Your Ref
AL/40/18/PL
Our Ref
PLAN-022702
Date
17/05/2018

Proposal: 2 No. semi-detached bungalows with associated parking & landscape
Site: Land Adjacent to 14 St Johns Close, Westergate, PO20 3TH.
AL/40/18/PL

location plan &
proposed site plan

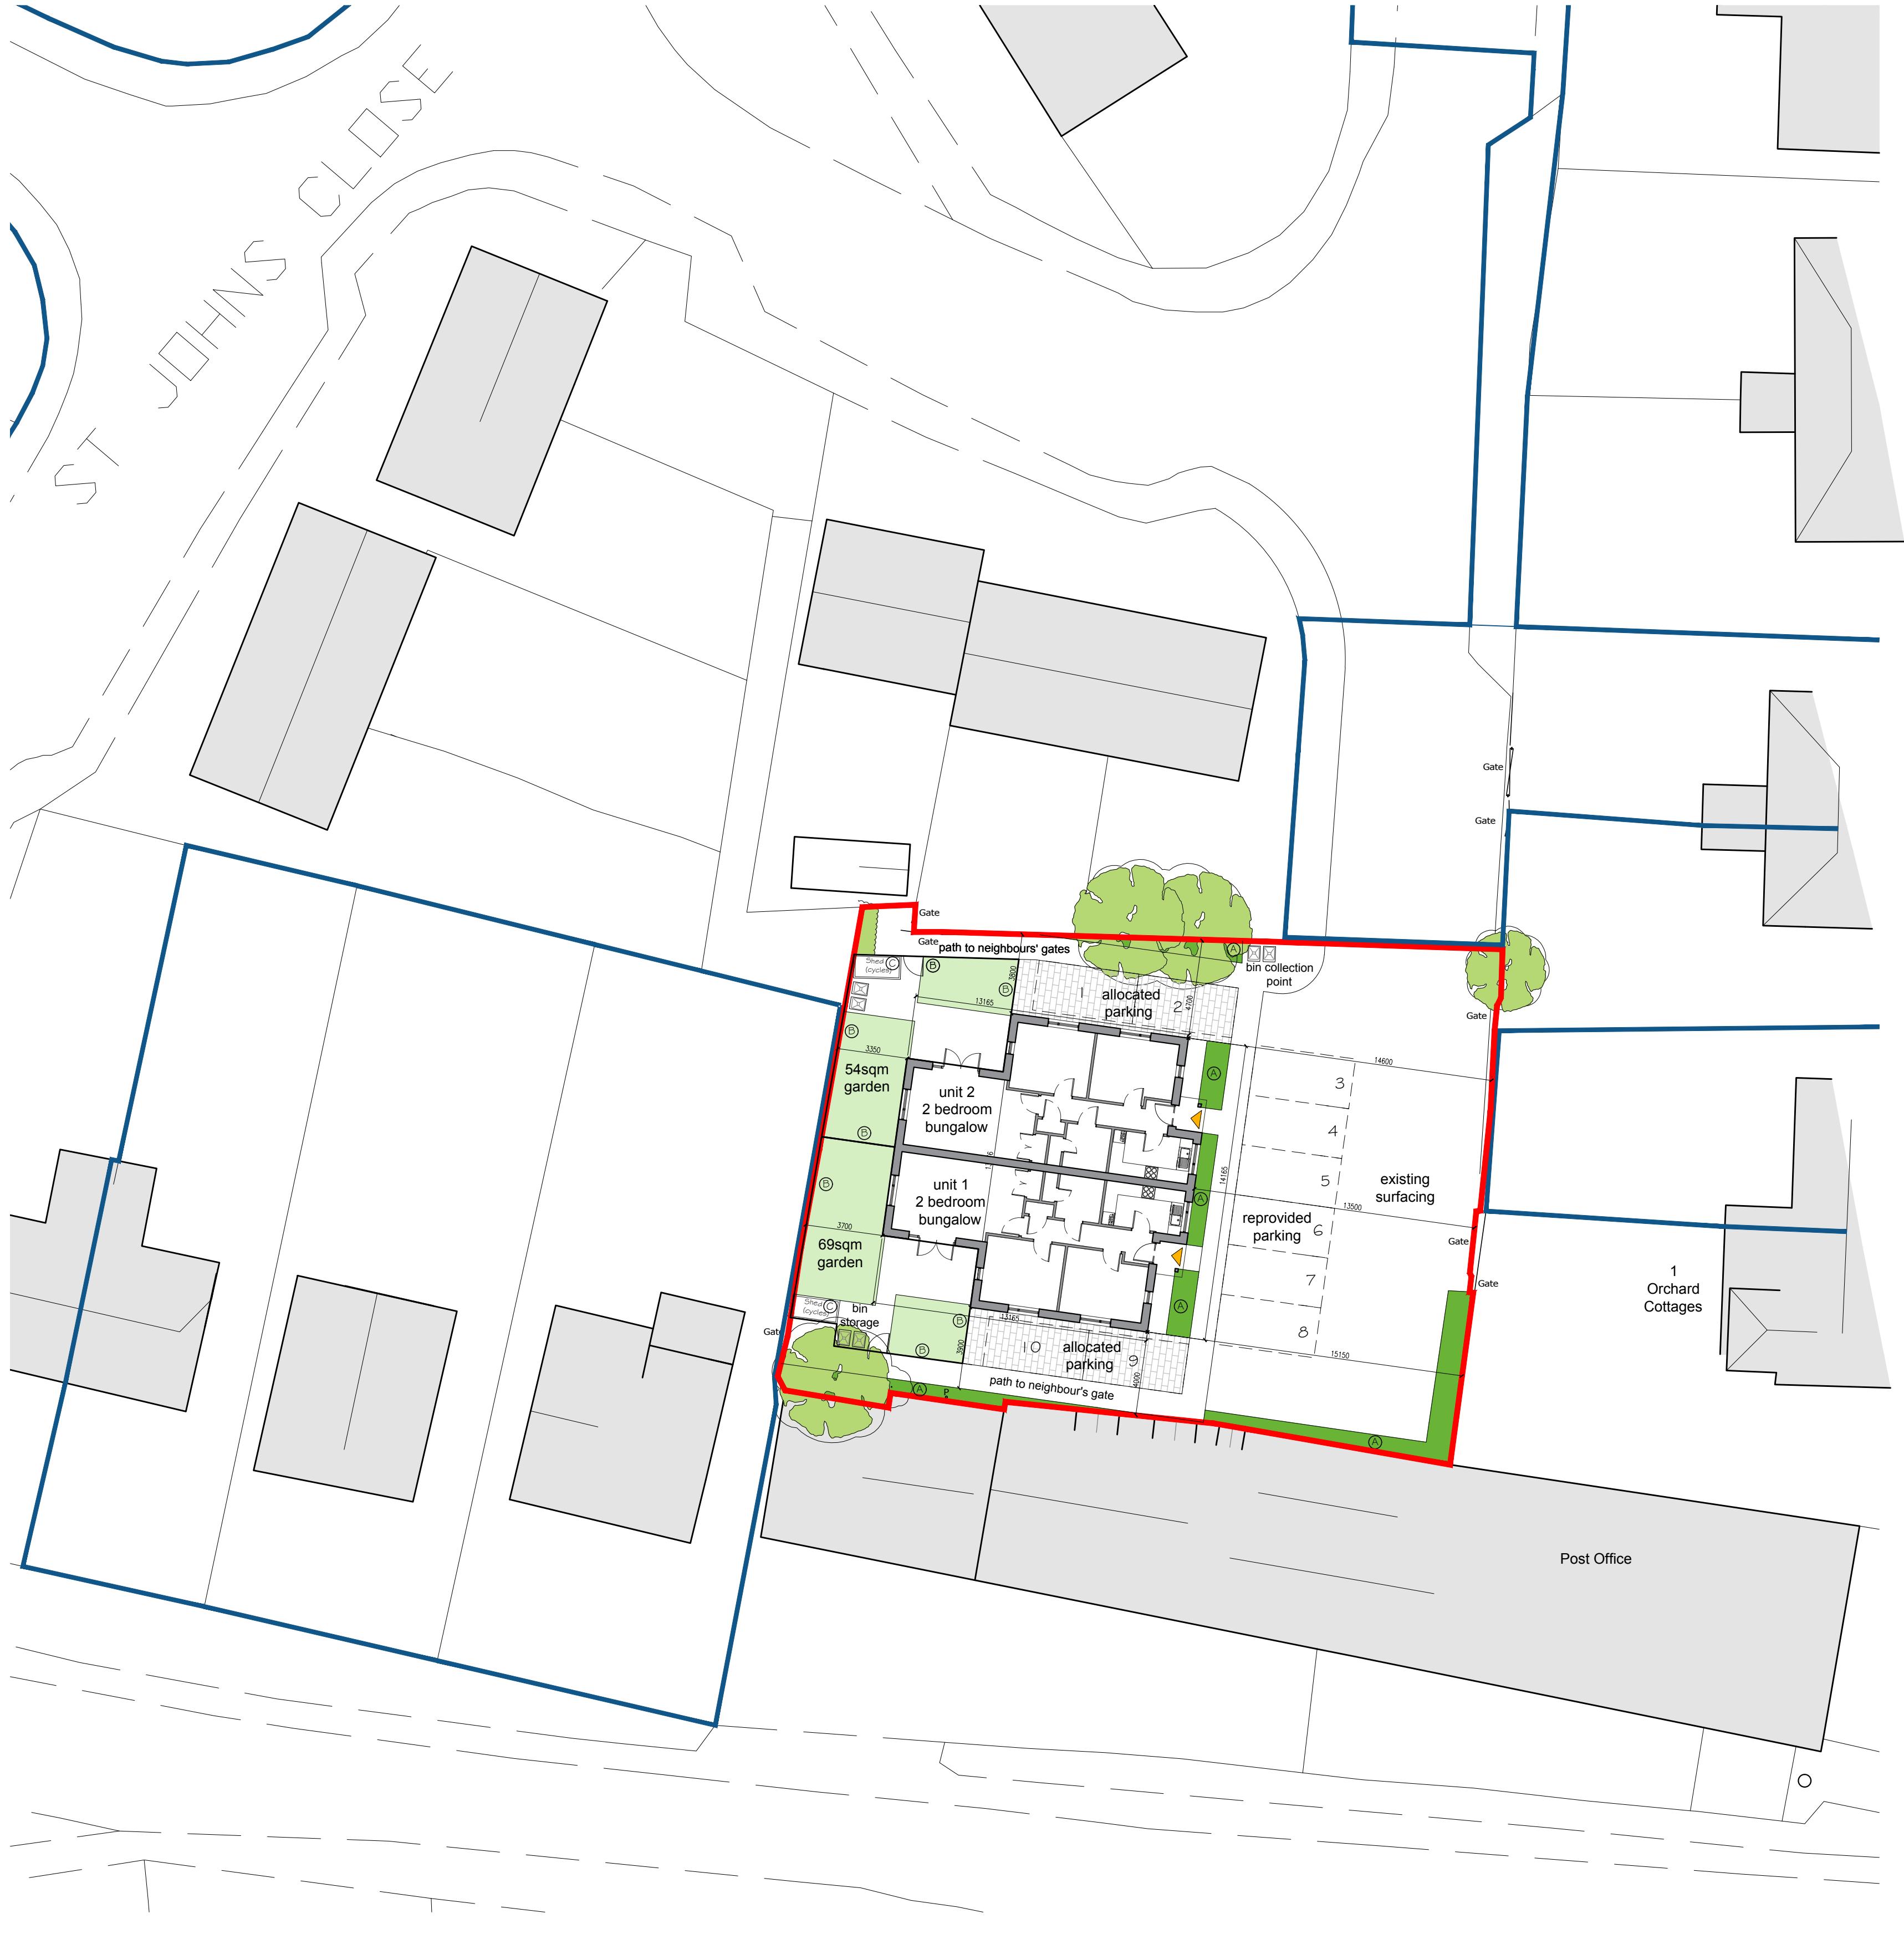
Please find attached a plan of the sewer records showing the approximate position of surface water sewer crossing the site. The exact position of the surface water sewers must be determined on site by the applicant before the layout of the proposed development is finalised.

1. The 150 mm diameter sewer requires a clearance of 3 metres either side of the sewer to protect it from construction works and allow for future access for maintenance.
2. No development or new tree planting should be located within 3 metres either side of the external edge of the public sewer
3. No new soakaways should be located within 5 metres of a public sewer.

The applicant has not stated details of means of disposal of foul drainage from the site.

The planning application form makes reference to drainage using Sustainable Urban Drainage Systems (SUDS).

In order to divert drainage apparatus, Southern Water requests that if consent is granted, a condition is attached to the planning permission. For example “The developer must advise the local authority (in consultation with Southern Water) of the measures which will be undertaken to divert the public sewers, prior to the commencement of the development.”

We request that should this application receive planning approval, the following condition is attached to the consent: "Construction of the development shall not commence until details of the proposed means of foul and surface water sewerage disposal have been submitted to, and approved in writing by, the Local Planning Authority in consultation with Southern Water."
